From: Anita Gardner
Sent: 29 January 2019 10:02
To: Planning.Responses
Subject: FW: LU/328/18/PL 90/91South Terrace, Littlehampton
Attachments: 955_DESIGN AND ACCESS STATEMENT REV A.PDF; 955_90ST_P05.pdf

From: Anita Gardner [mailto:Anita.Gardner@arun.gov.uk]
Sent: 28 January 2019 10:15
To: Edmund T. Green [REDACTED]
Subject: RE: LU/328/18/PL 90/91 South Terrace, Littlehampton

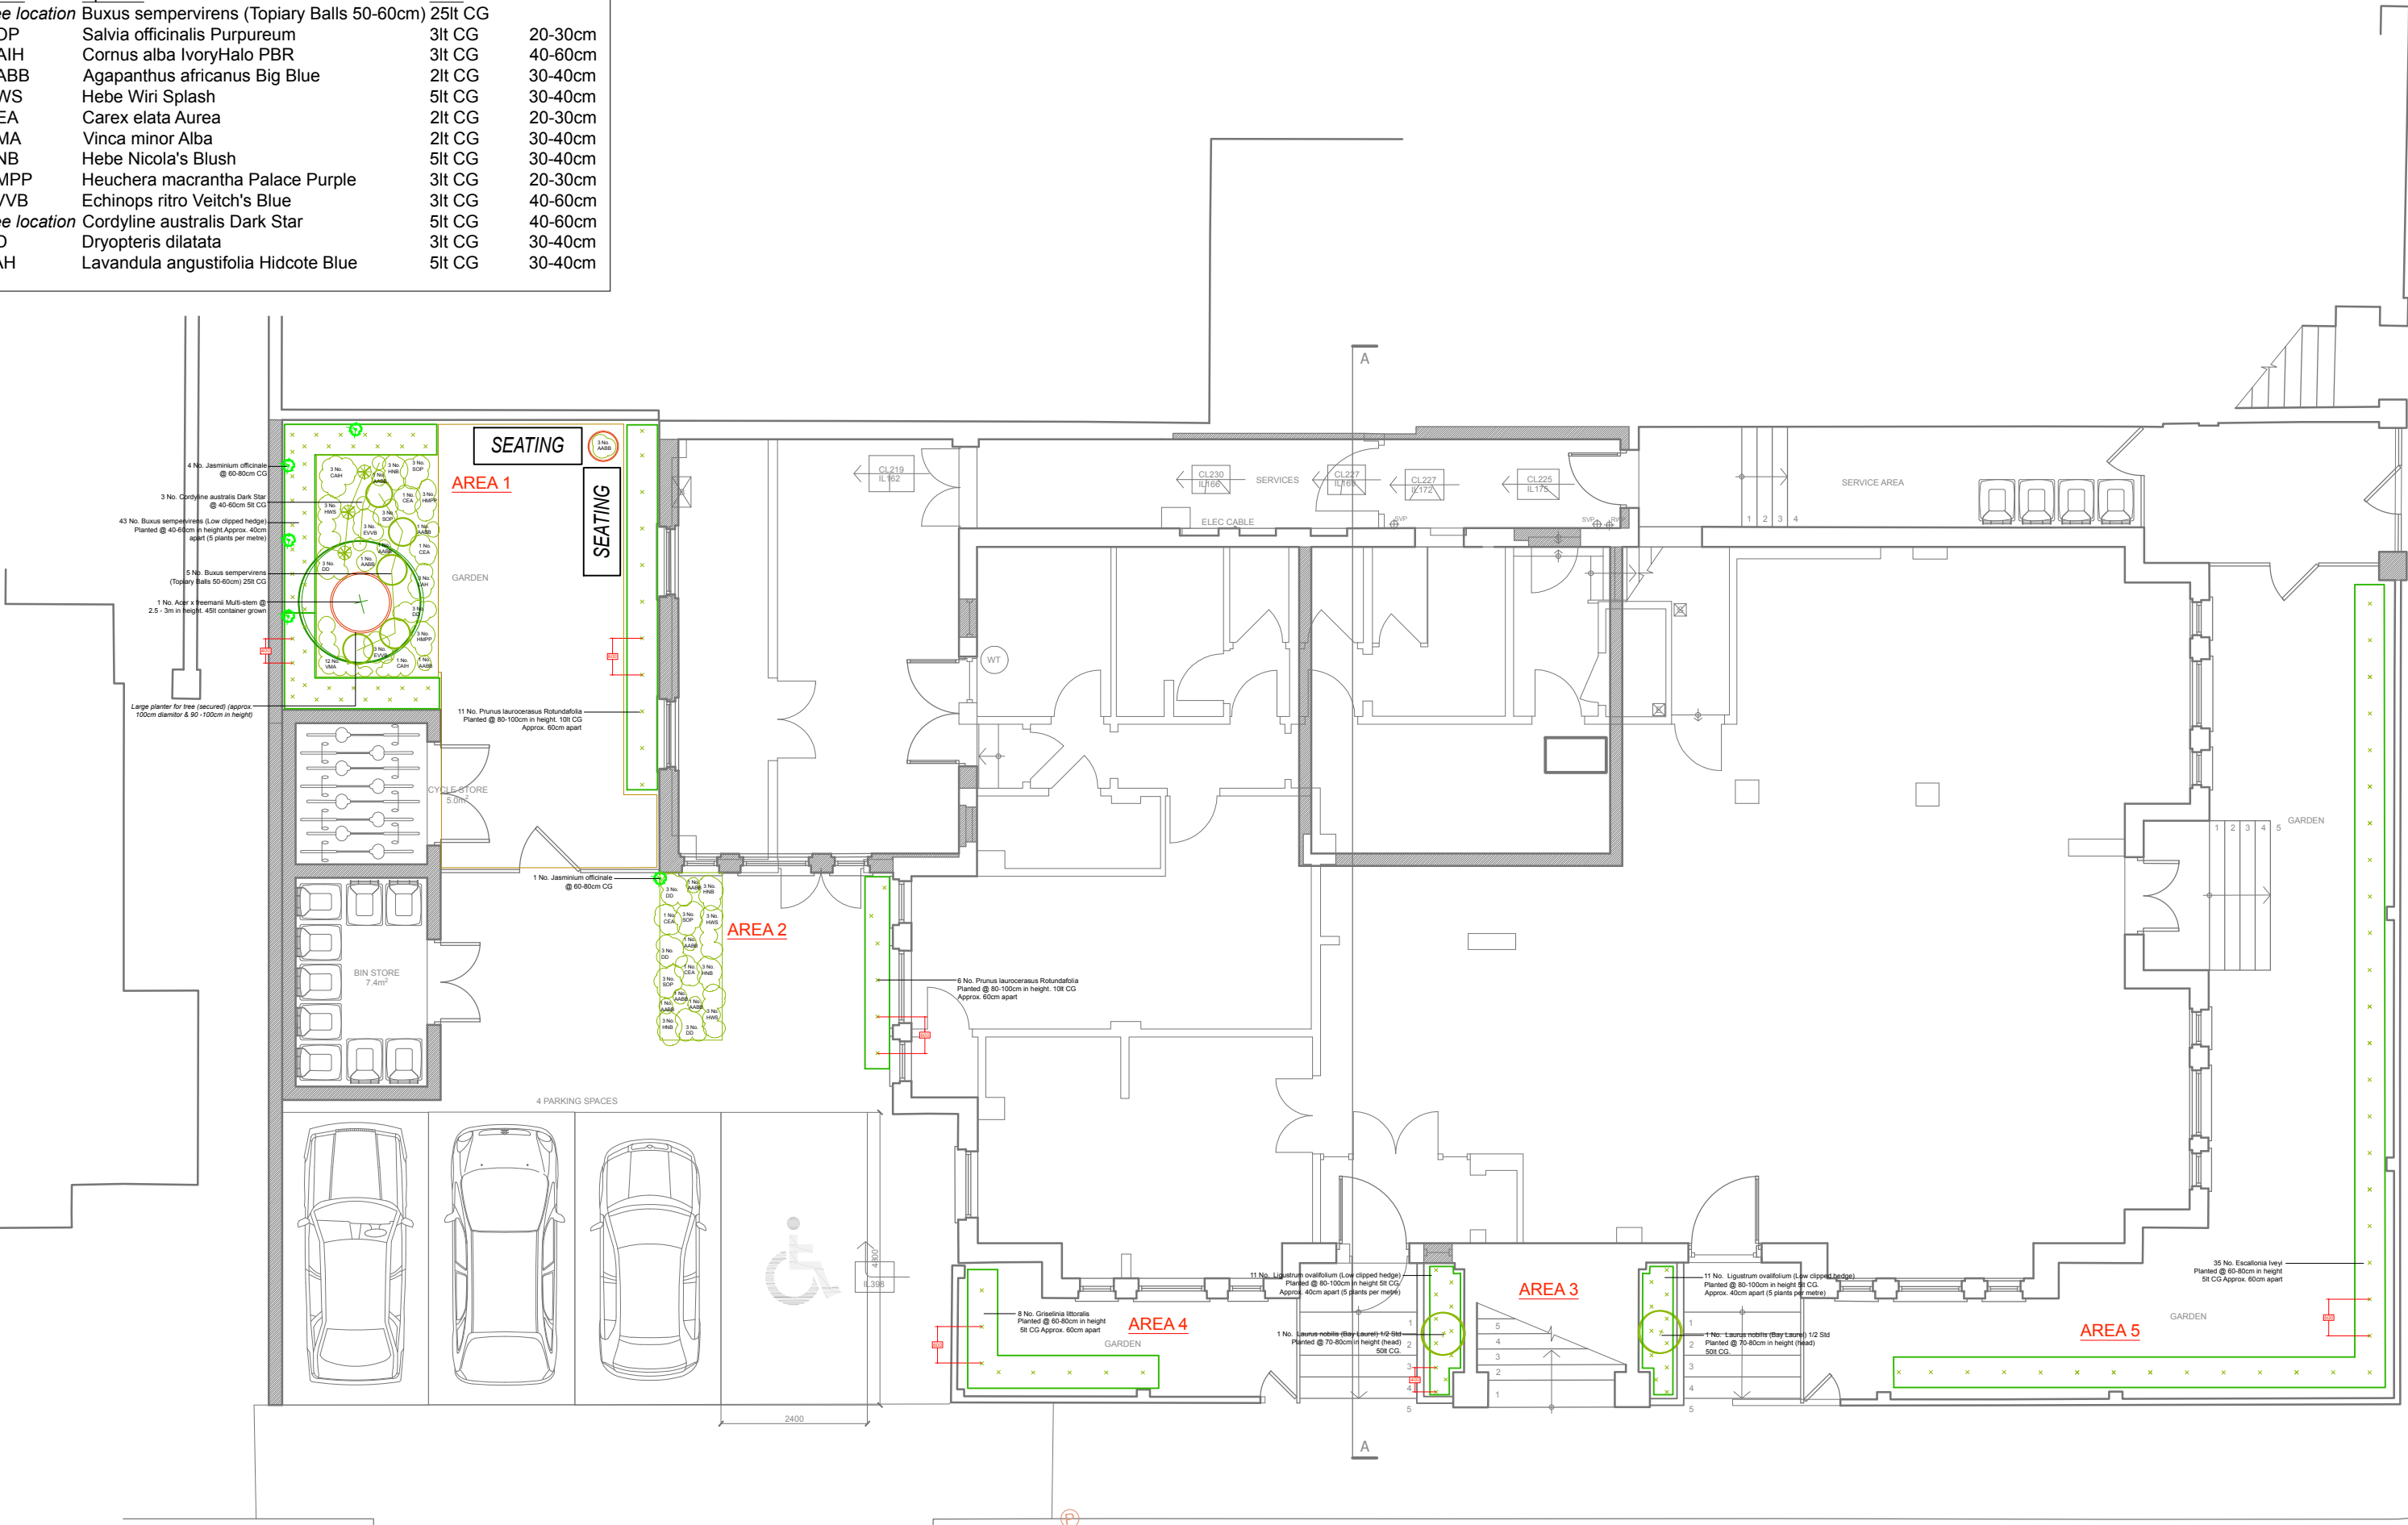
Hi Edmund,
Please can you indicate the railings on the landscaping layout plans and the street scene
Regards
Anita

I hope you are well. Please find the attached revised landscaping scheme showing the railings as requested. Please confirm receipt of the attached.
